RE: ENGINEER'S CERTIFICATION FOR P.M.I. WAREHOUSE
(C-17/D15) ENGINEER'S STATEMENT DATED AUGUST 30, 1989

RE: REVISED DRAINAGE PLAN FOR P.M.I. WAREHOUSE (C-17/D15)
REVISION DATED JULY 26, 1989

RE: REVISED DRAINAGE PLAN FOR P.M.I. WAREHOUSE (C-17/D15)
RECEIVED JULY 26, 1989

RE: REVISED DRAINAGE PLAN FOR P.M.I. WAREHOUSE (C-17/D15)
RECEIVED JUNE 22, 1989

GRADING & DRAINAGE PLAN

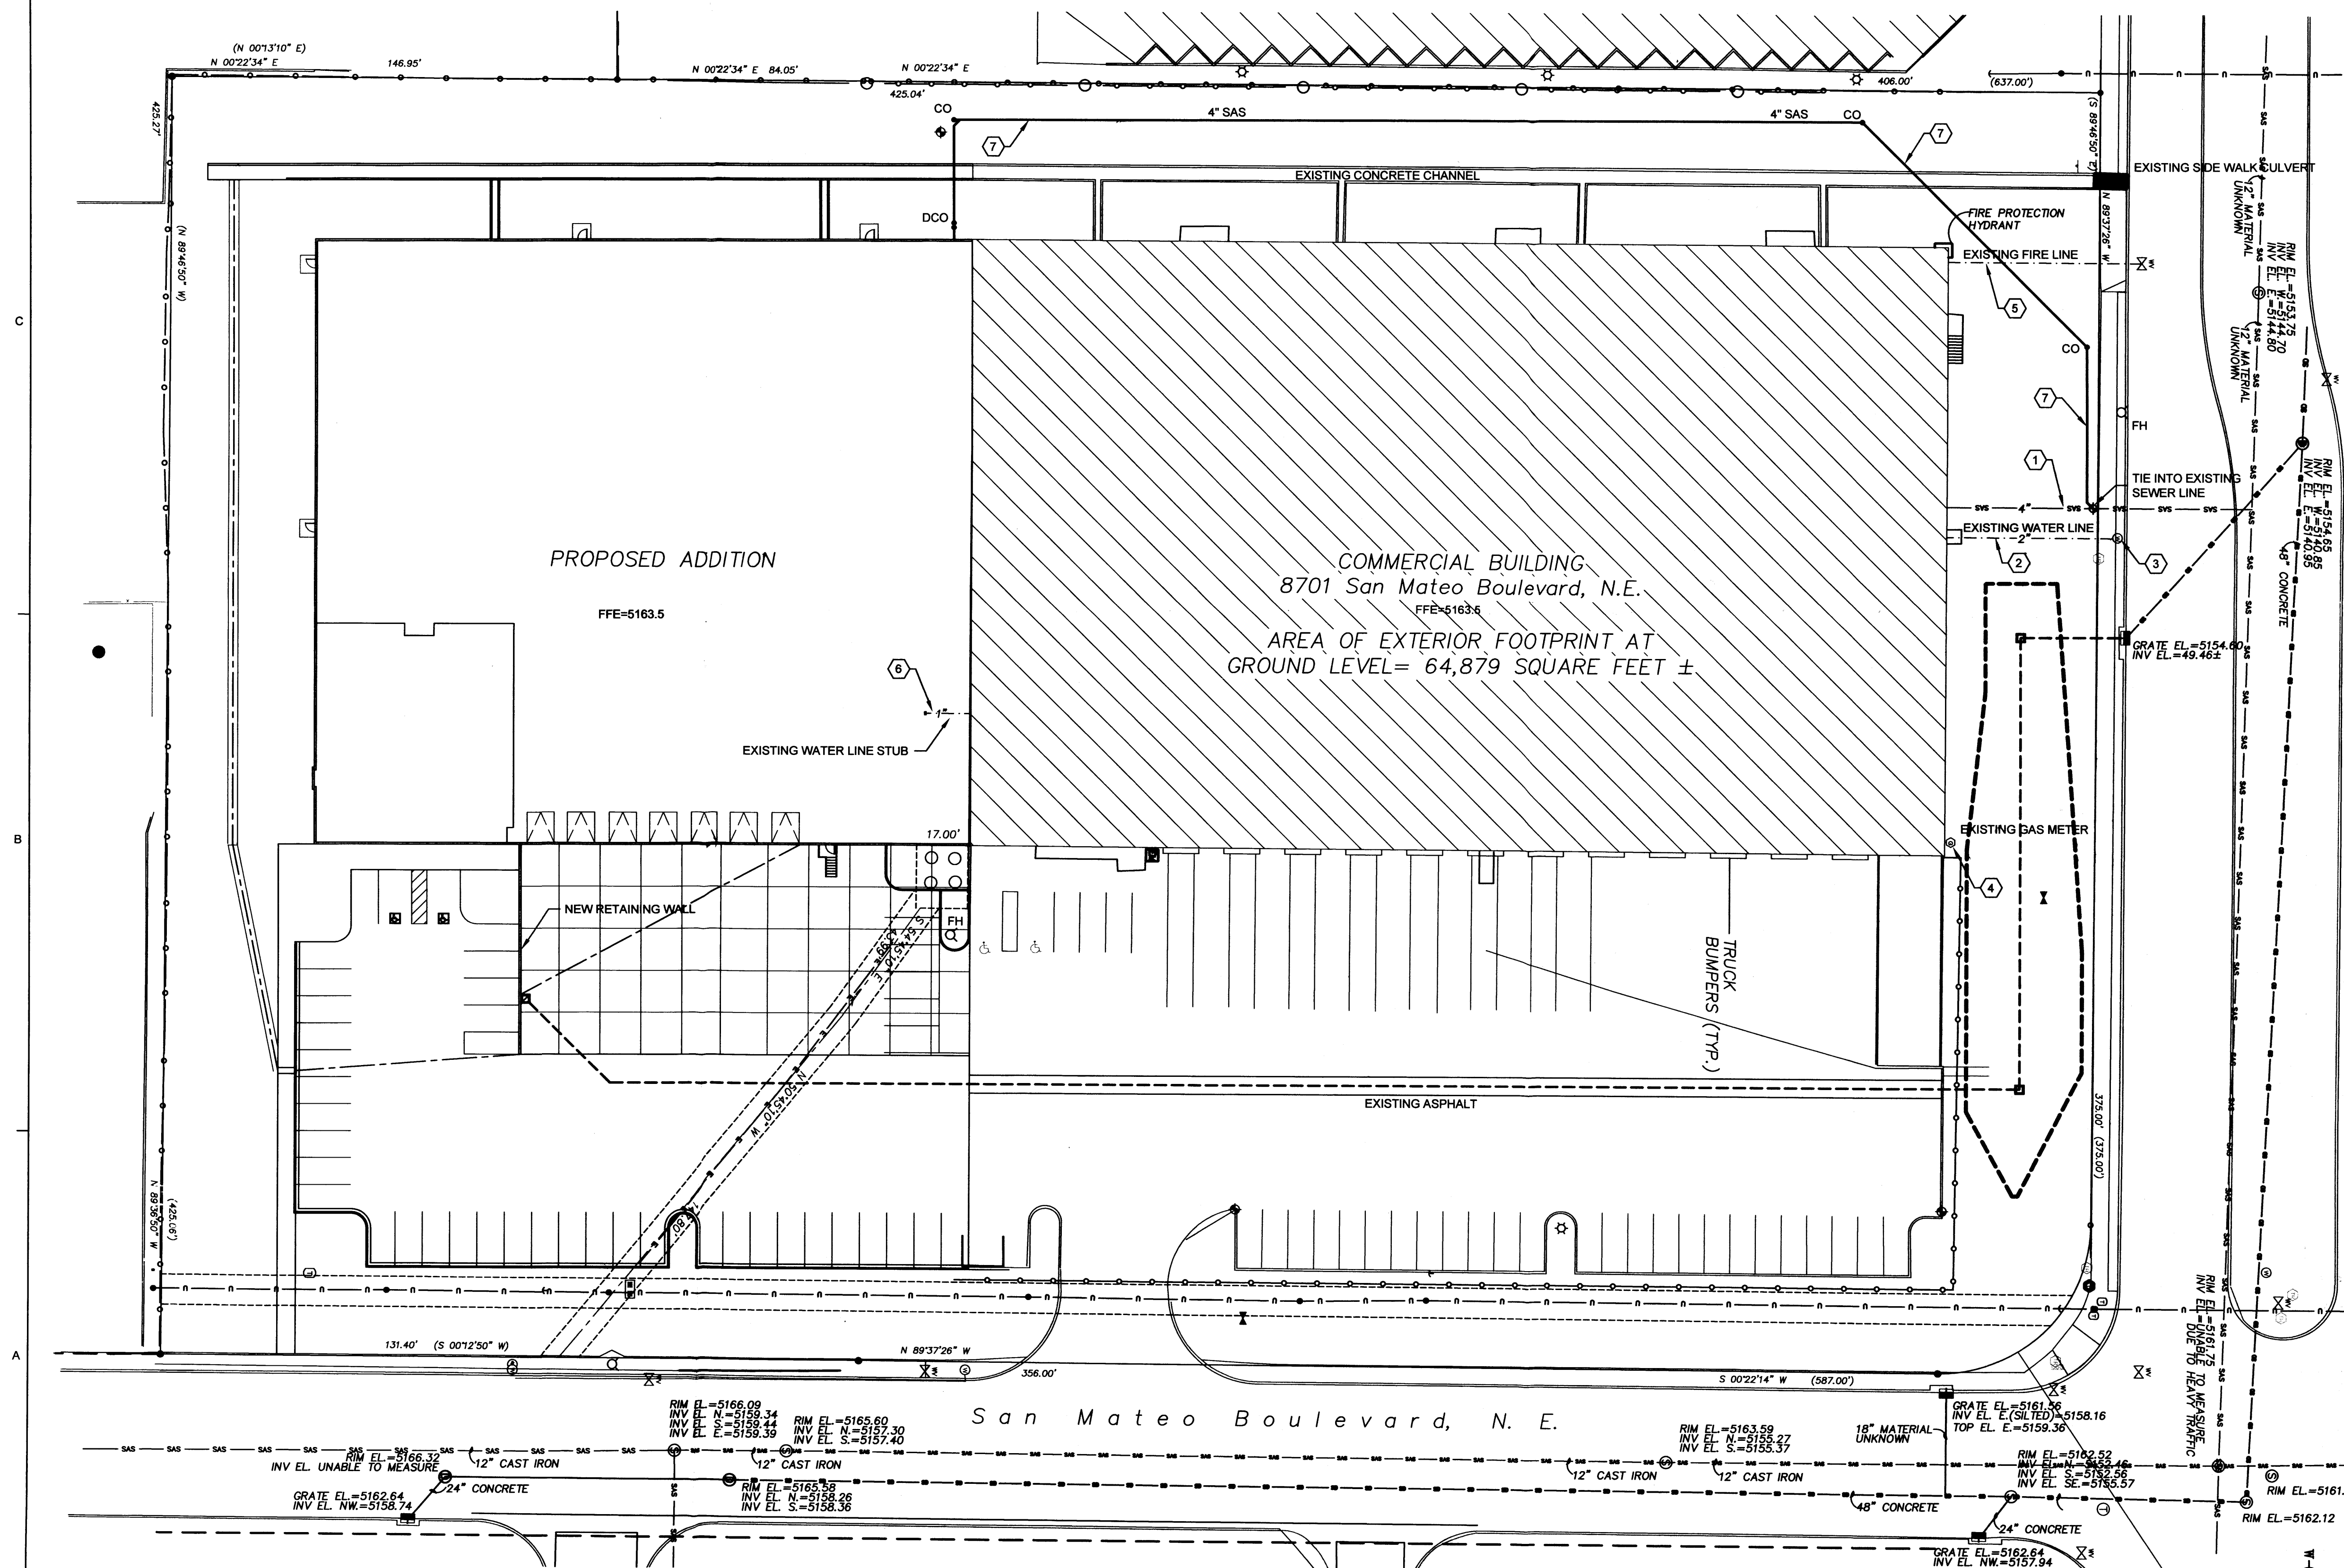
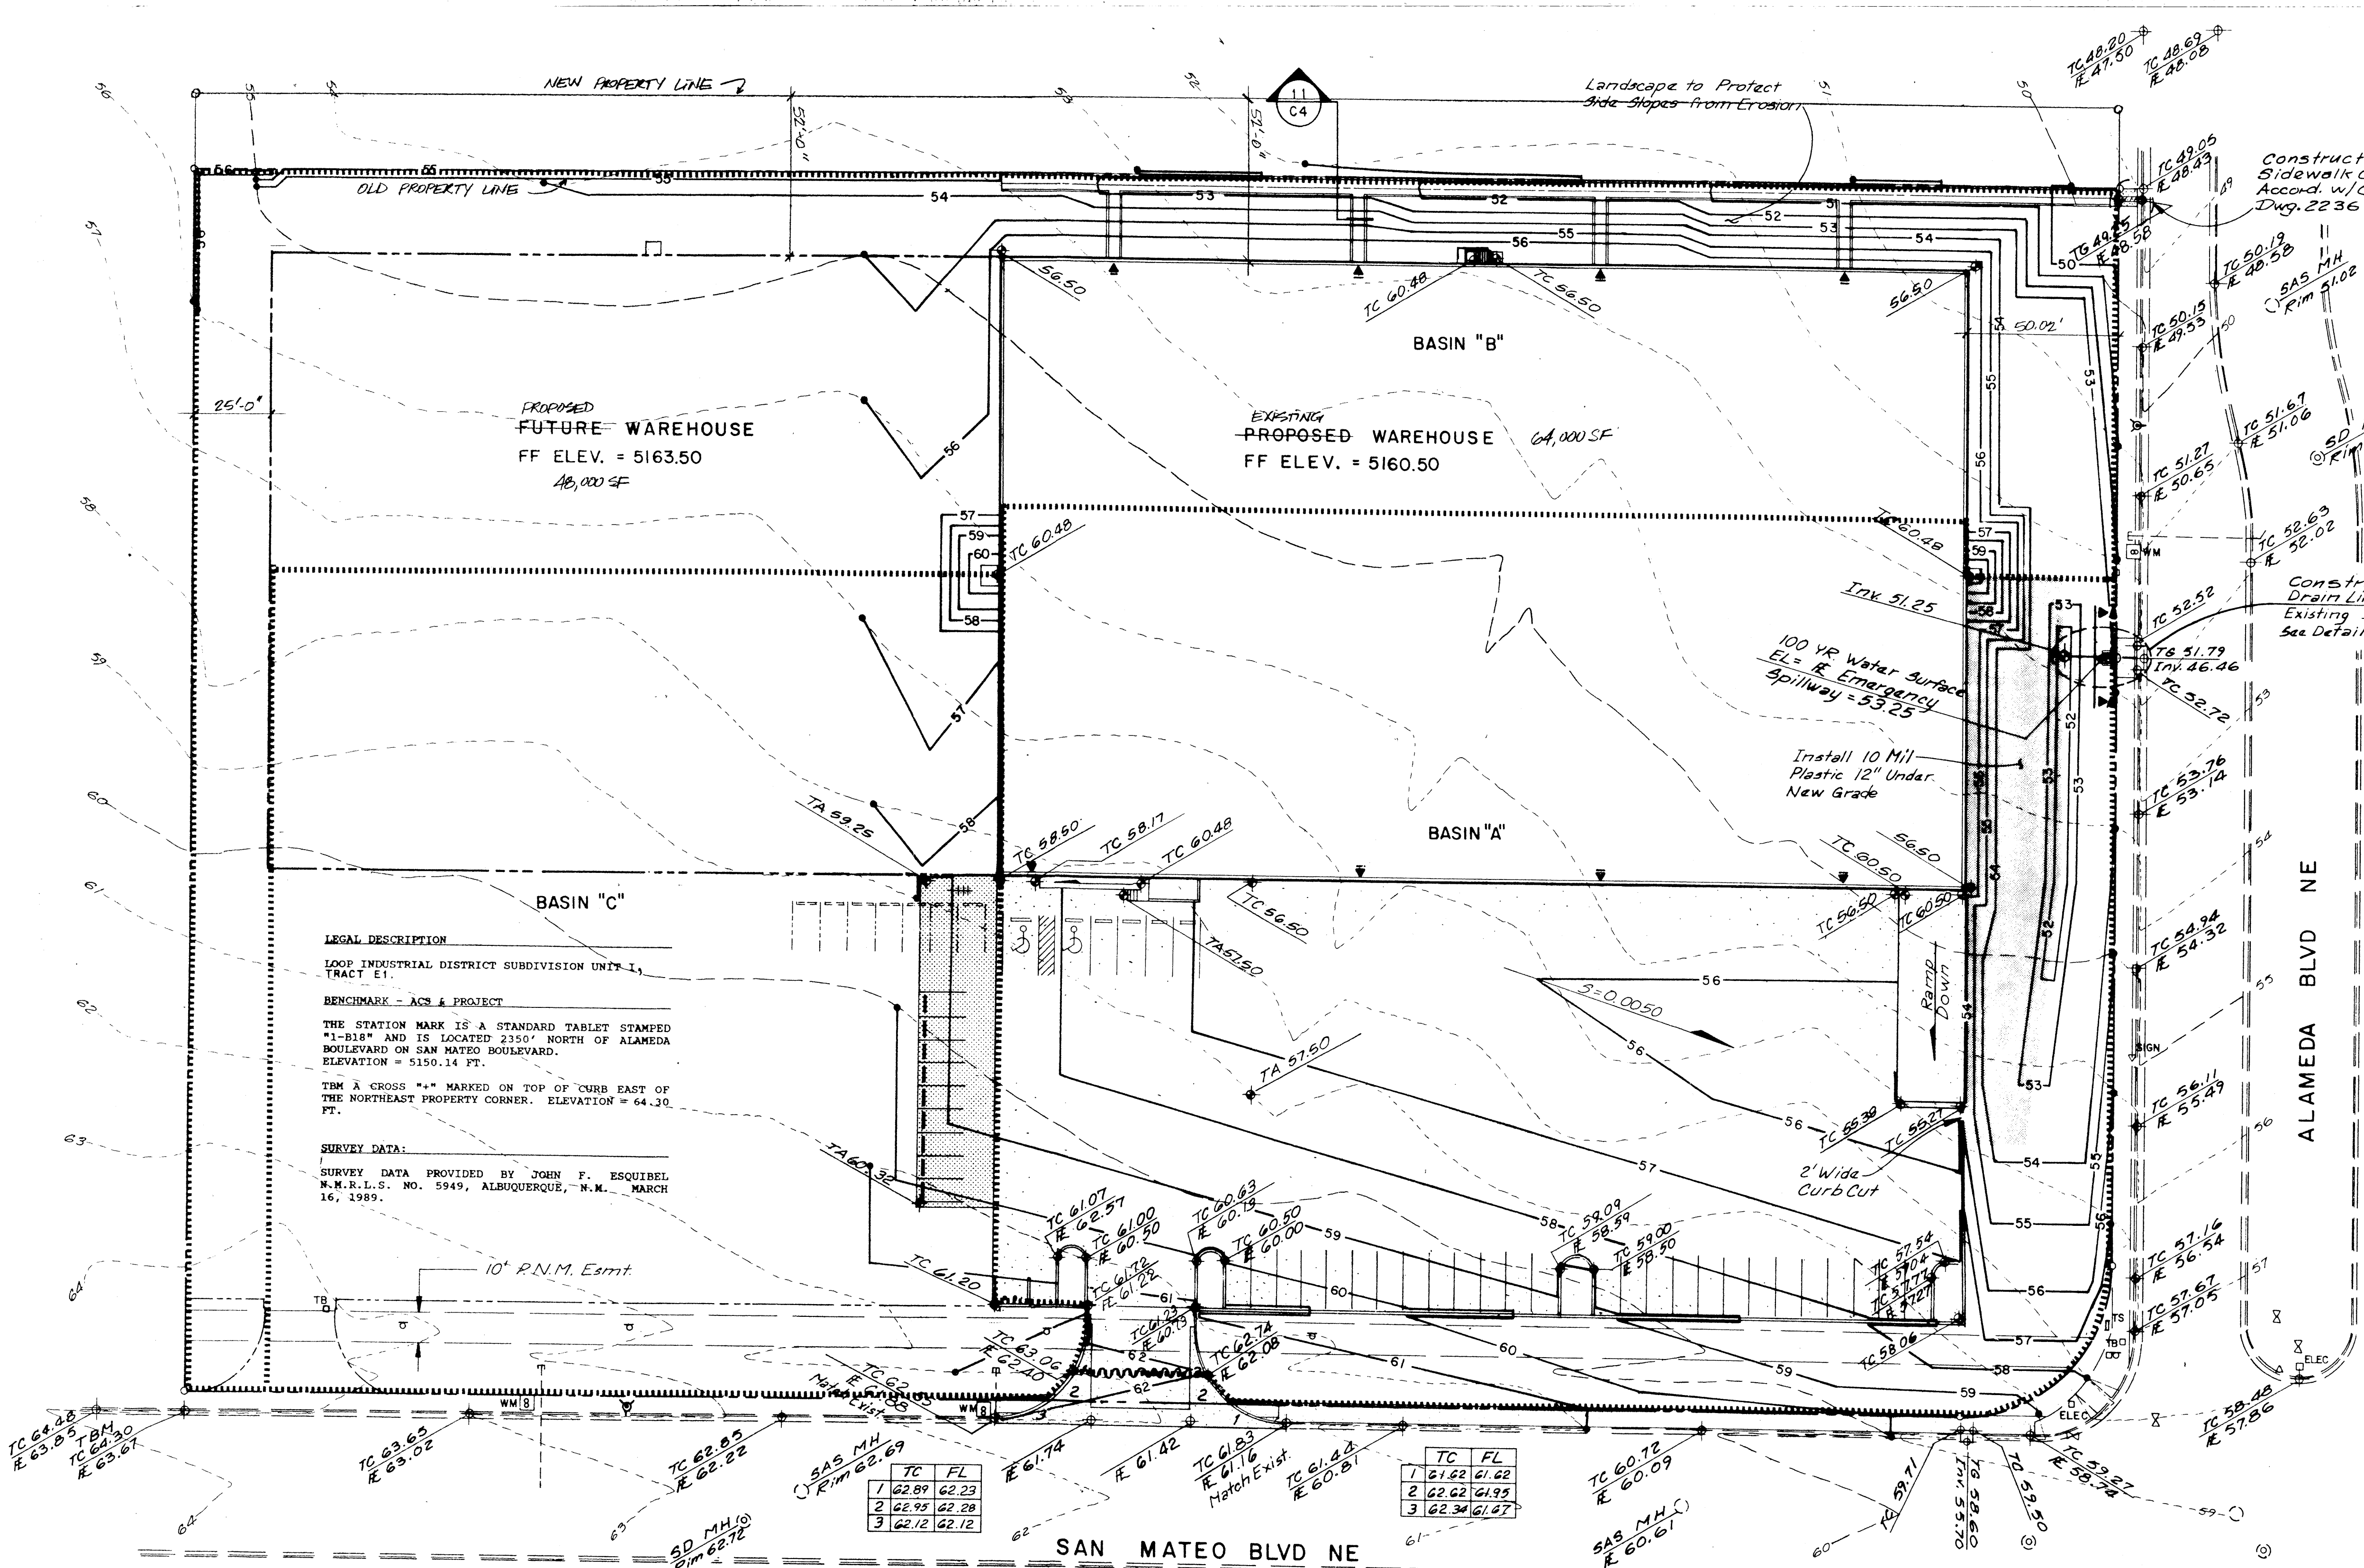
1. Traffic Engineering will not allow for a standard 24' wide drive pad to be constructed for the sole purpose of developed runoff discharge.
2. If you can redesign your outlet point to not cause damage by letting the Q_{100} overflow the sidewalk culverts, then you will be allowed to release only the Q_{10} through the sidewalk culverts. Our concern is damage to the property to the west. Protection must be provided so that the overflow goes into the street.
3. Recompute your basins and show what the accumulated Q_{10} will be.

1. Your resubmittal indicates that between Basin A and B, and eventually Basin C, you will have an accumulated $Q = 19.35$ cfs. All will be routed to the proposed sidewalk culvert which can only handle 4.73 cfs. Please address.
2. What type of landscaping or vegetation do you propose for erosion control from the notch on the curb to the proposed sidewalk culvert?
3. How do you propose to get the runoff from Basin A & C into the sidewalk culvert?

1. Break up the drainage basins, indicate which and what amount will be routed to the proposed 24" culvert and which will be routed to the pond.
2. It may be beneficial to interconnect all the roof gutters on the west side of the building and outlet them at the proposed sidewalk culvert.
3. You must compute your volumes using the CN values for .78 and .75 separately to determine the ponding requirement.
4. Please quantify the amount of ponding provided with your design.
5. Please identify the 100 year water surface elevation along with the emergency spillway elevation within the plan drawing.
6. You must use the rectangular orifice equation to compute your sidewalk culvert discharge rate.
7. Further research into SAD 201 indicates that free discharge may be appropriate. If you do an analysis of downstream capacity, it may turn out that free discharge may be granted.
